H2Teesside Project

Document Reference: 9.7: Statement of Common Ground between H2 Teesside Limited and Natural England

Date: September 2024

**Statement of Common Ground between the H2 Teesside Limited and
Natural England**

**FIGURE NUMBER**  
Figure 10-19a

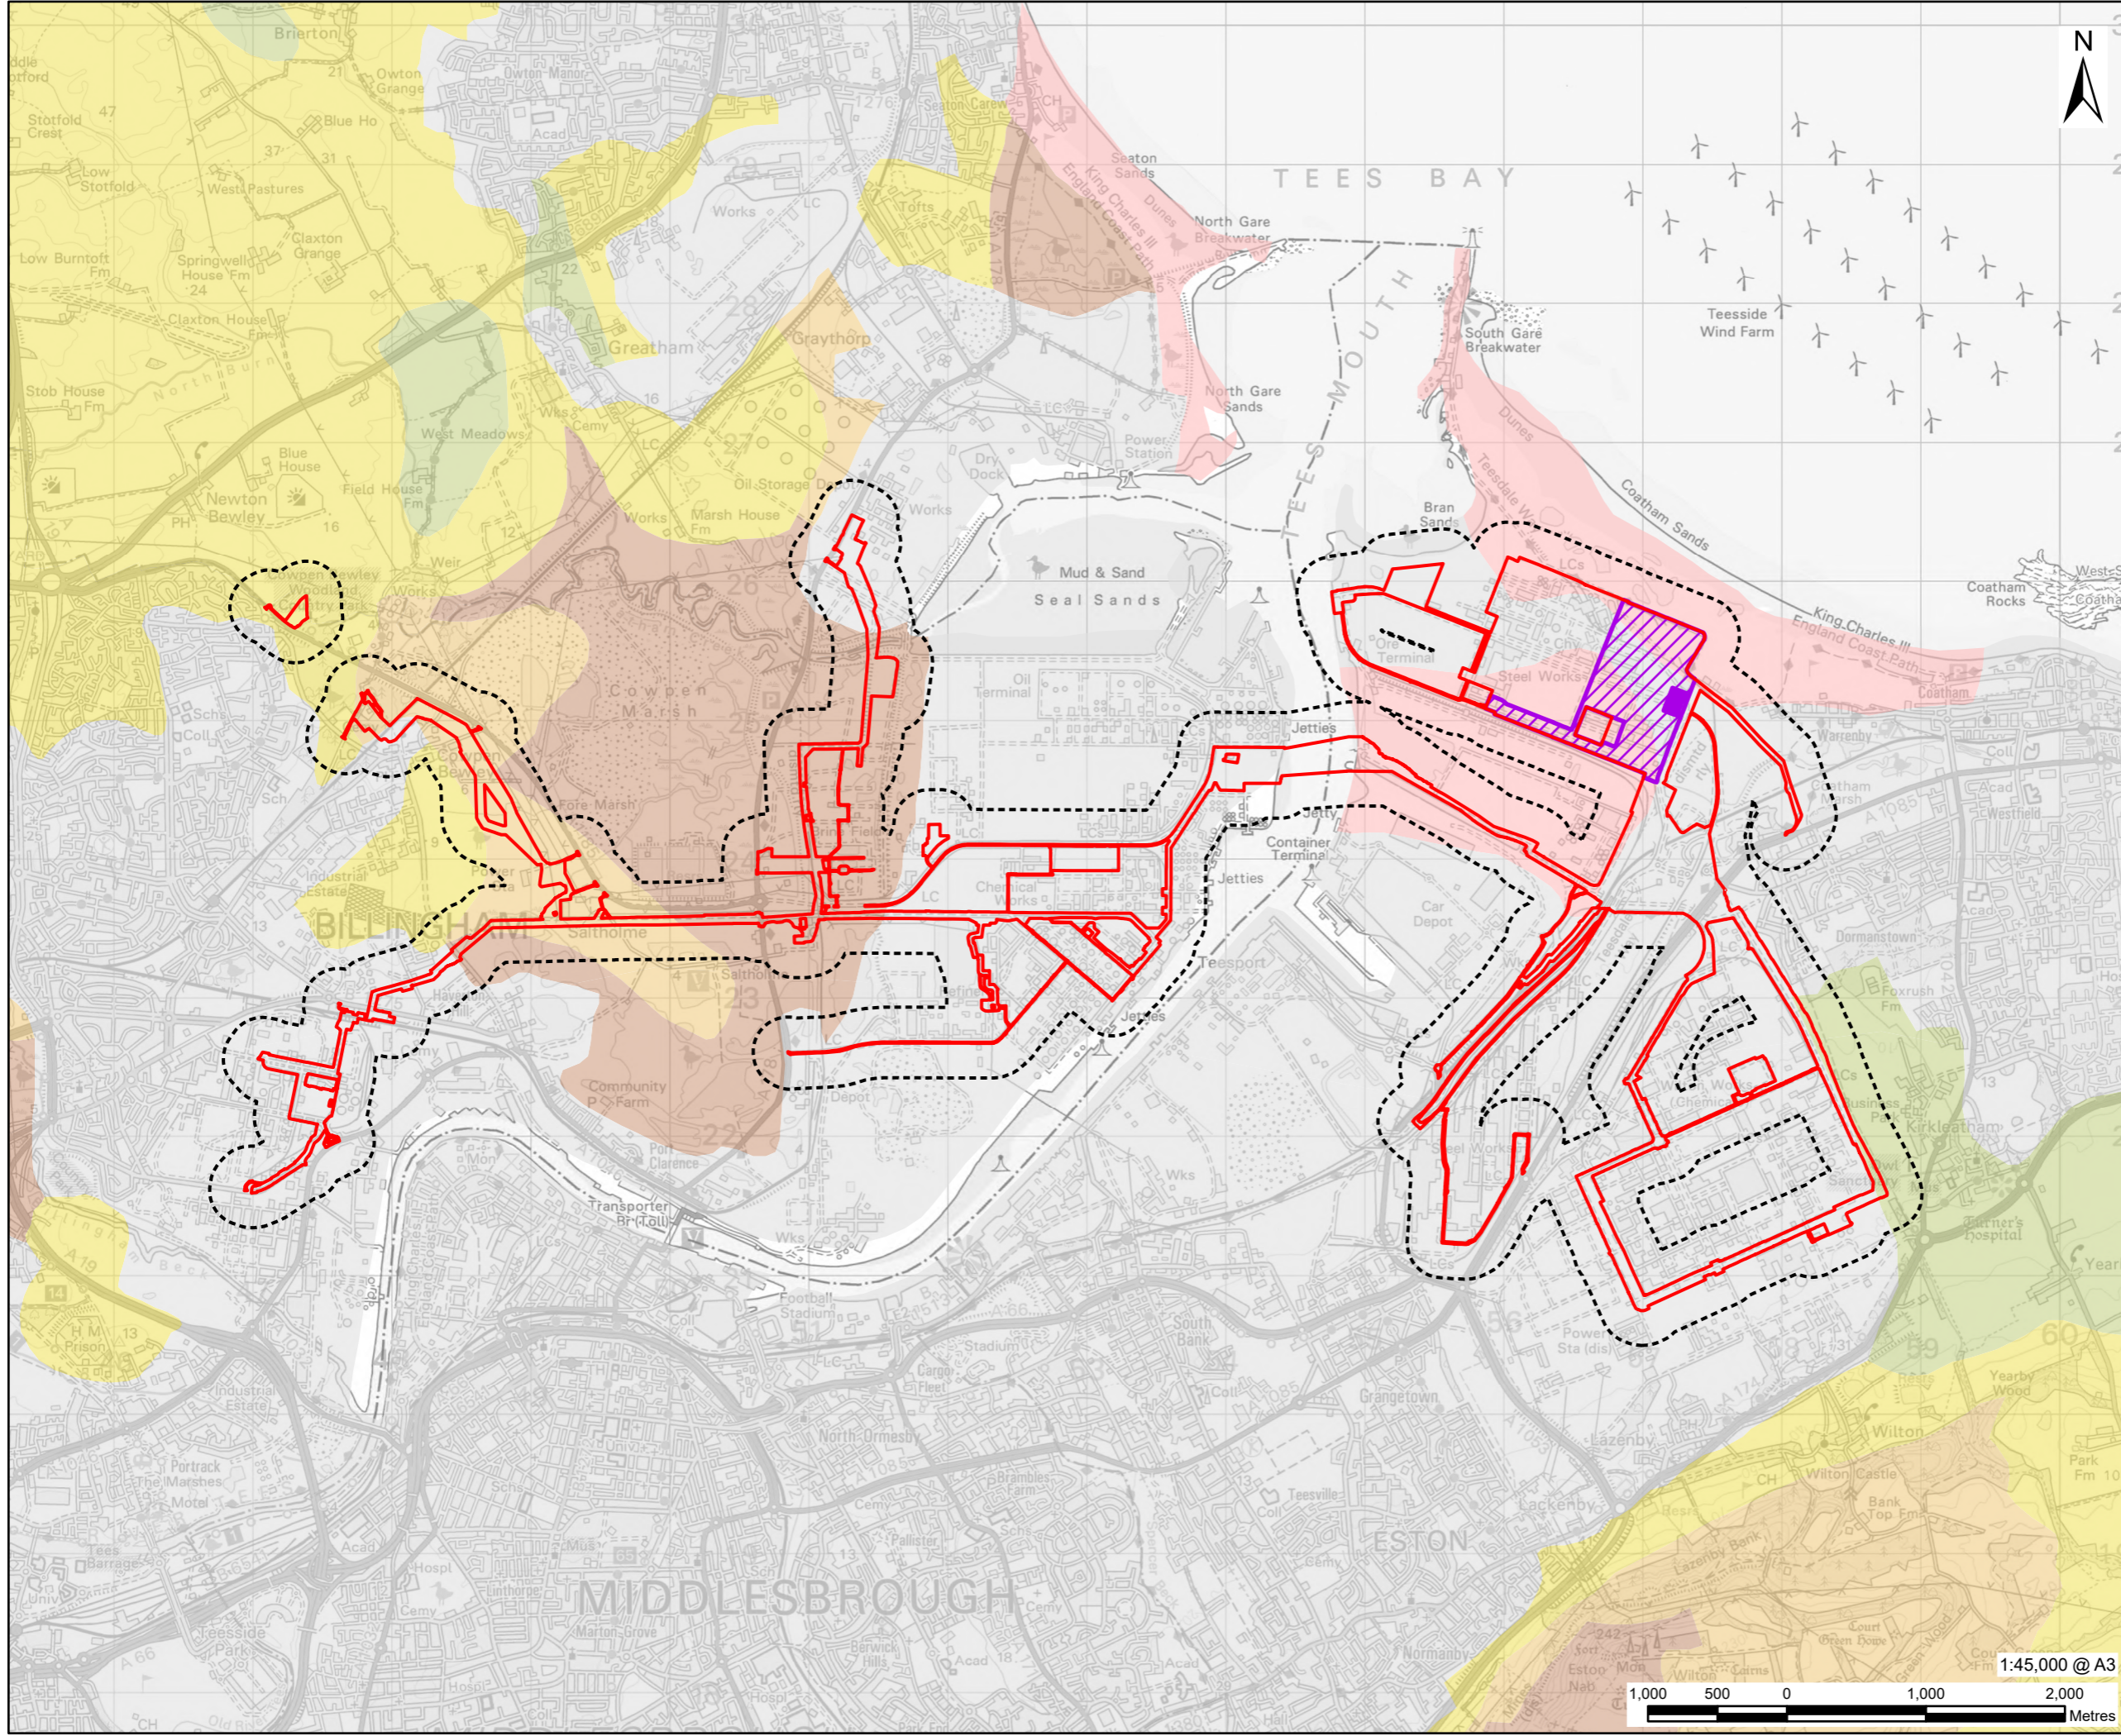
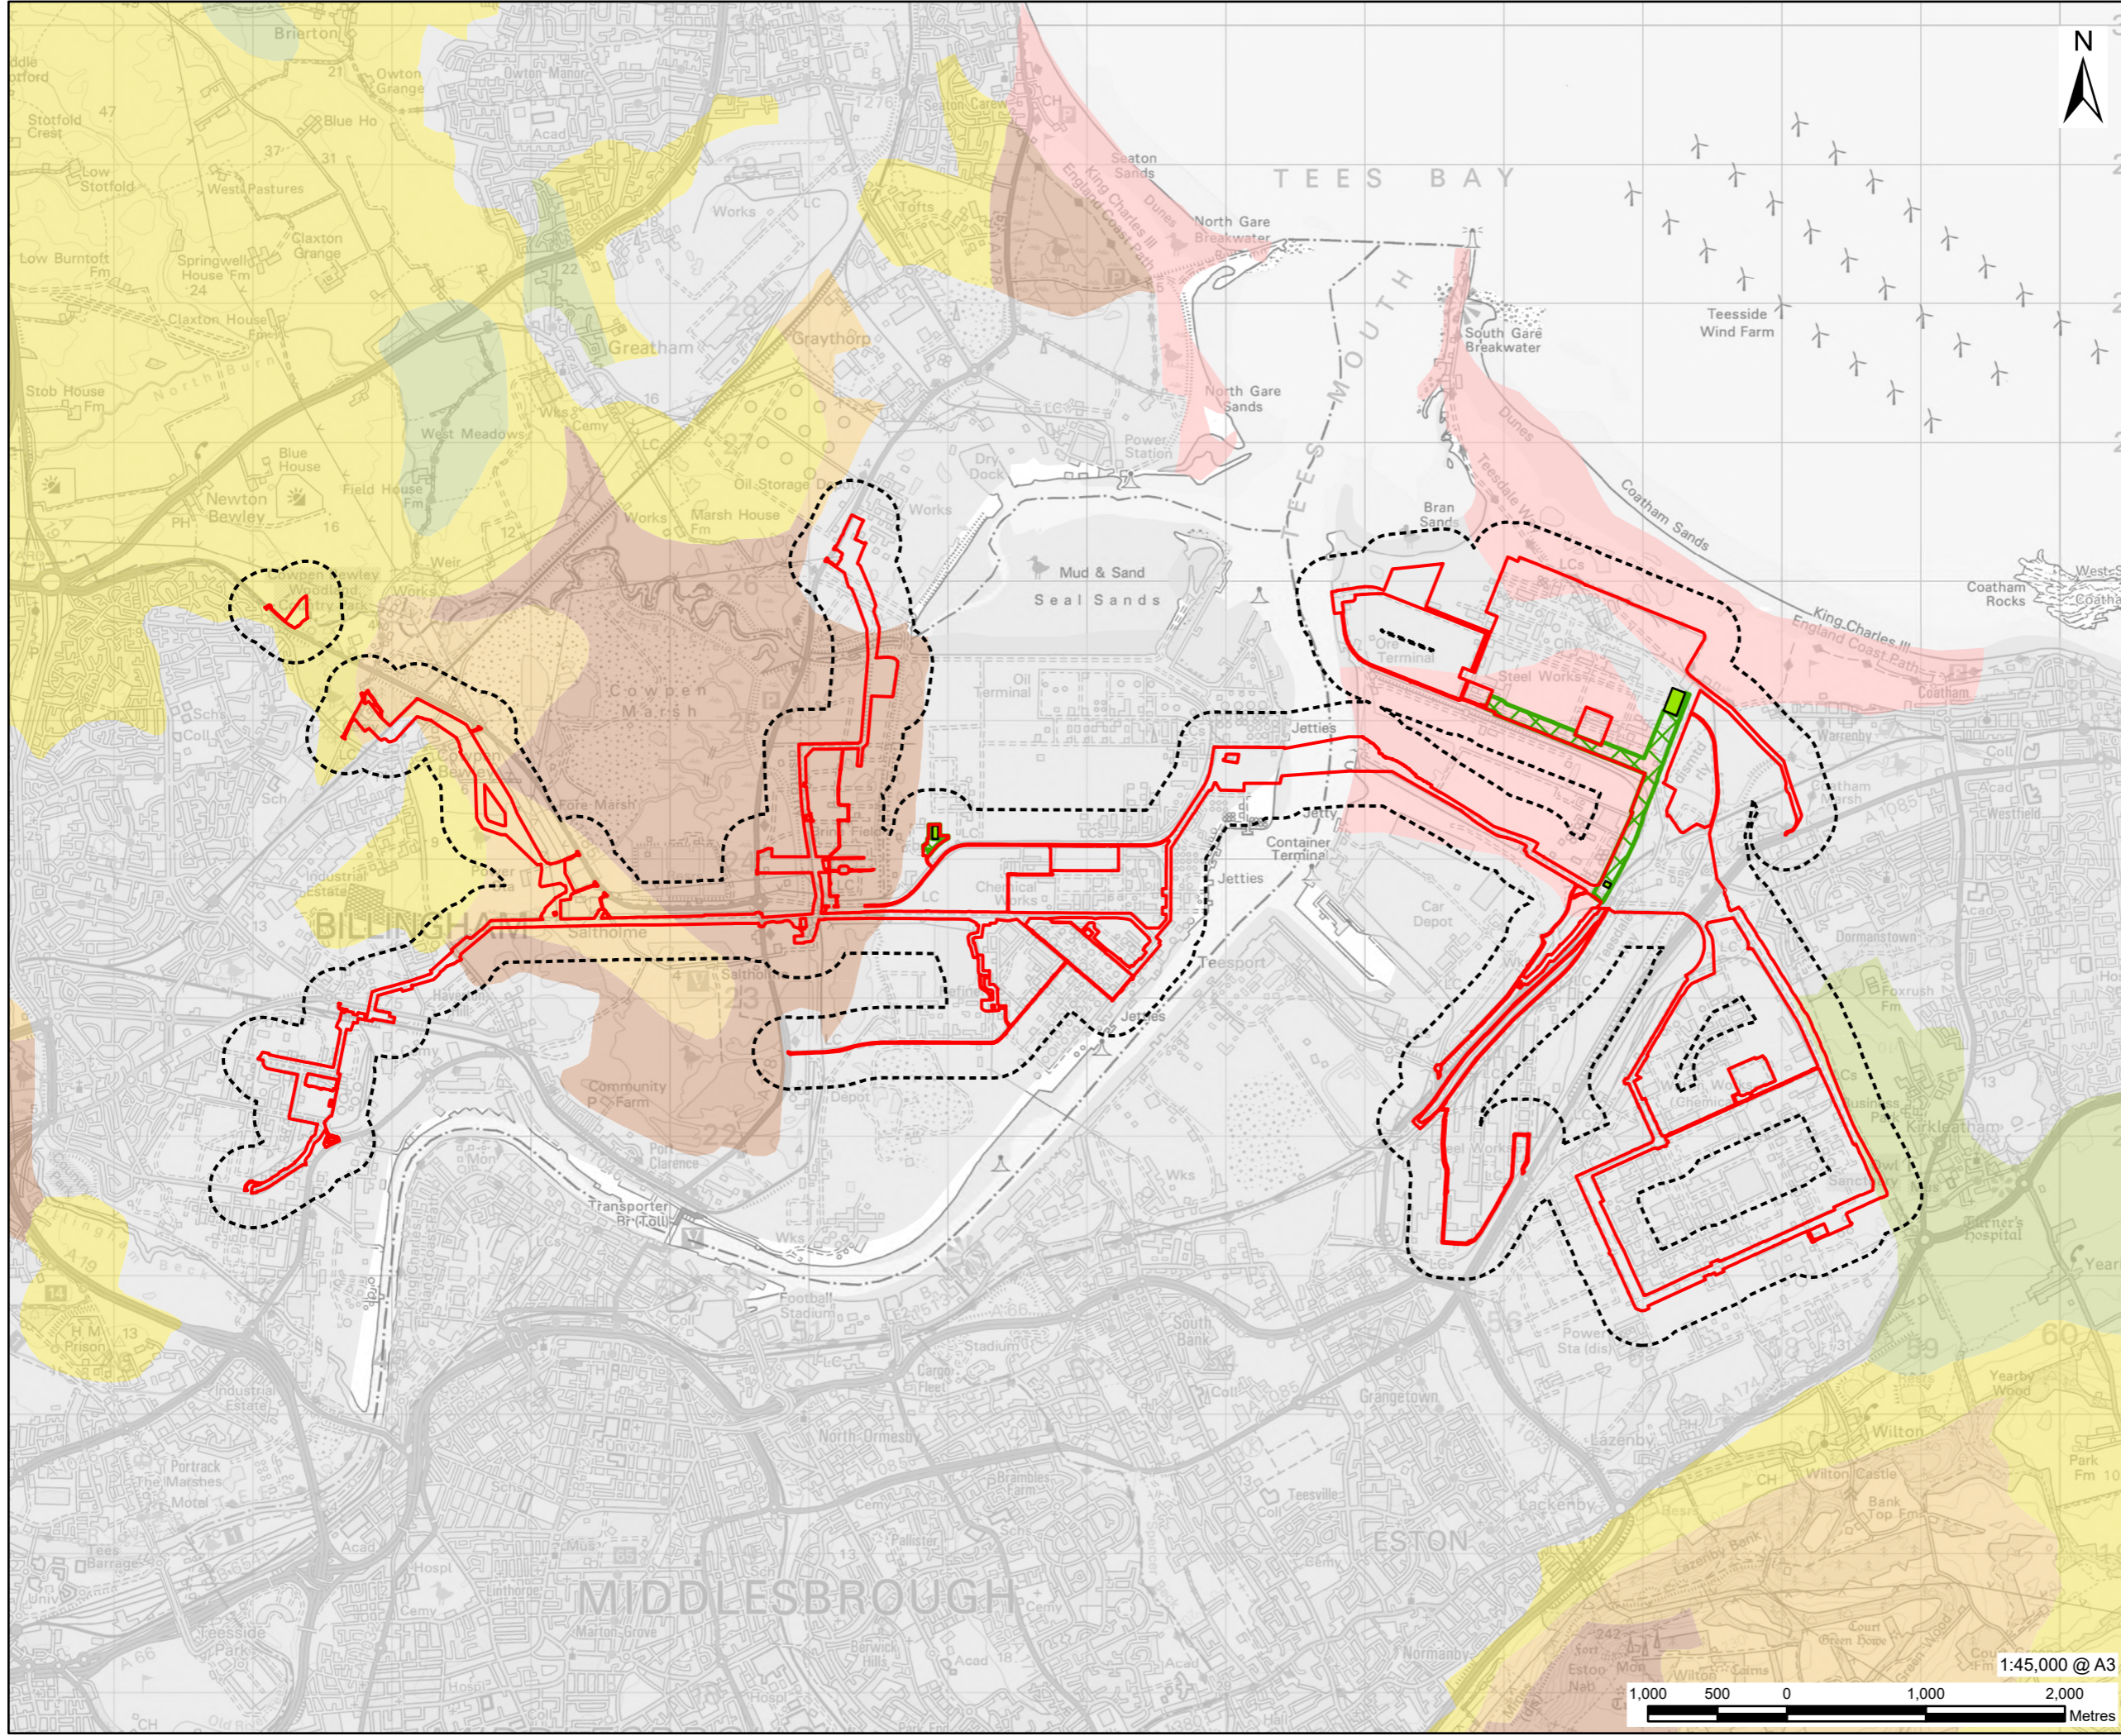
11.	Best and Most Versatile Land	<p>BMV land across the Proposed Development Site is limited, with the majority of the Main Site and Connection Corridors classified as Urban and Non-Agricultural. A small portion of the Hydrogen Pipeline Corridor north of the River Tees has land classified as Grade 3, 4 and 5. As a worst case scenario Grade 3 land, at the Cowpen Bewley Replacement Land, is assumed to be Grade 3a, making it BMV land for the purposes of the</p>	<p>NE considers appropriate mitigation to prevent the loss of BMV land, should be set out within the assessment. This would require a detailed ALC survey of the pipeline routes to inform restoration. The following actions should be undertaken:</p> <ul style="list-style-type: none"> • For all areas in which POST-1988 ALC Survey information is not available, an ALC survey should be undertaken. • The colours used for mapping should be updated to match standard ALC colours.

SOCG ID	MATTER	APPLICANT POSITION	NATURAL ENGLAND POSITION
		<p>assessment presented in ES Chapter 10 ‘Geology, Hydrogeology and Contaminated Land’ [APP-062].</p> <p>Taking into account the above, the Applicant does not propose to undertake supplementary ALC surveys of the Proposed Development Site at this time. However, the Applicant recognises the need for careful soil management and handling. The Framework CEMP [APP-043] will be amended to include the production of a Soils Management Plan (‘SMP’), included as part of the Final CEMP, produced prior to construction.</p> <p>ES Figure 10-1 [APP-110] is for artificial geology/made ground only. ES Figure 10-19 [APP-137] will be updated to include the correct colours for each ALC grade at Deadline 2.</p> <p>No further updates are anticipated to be submitted.</p>	<ul style="list-style-type: none"> • The soil information presented (Figure 10-1 [APP-110]), should include the mapped soil associations. • The consideration of soil handling should be expanded in a Soils Management Plan (SMP) (Ref. NE35).
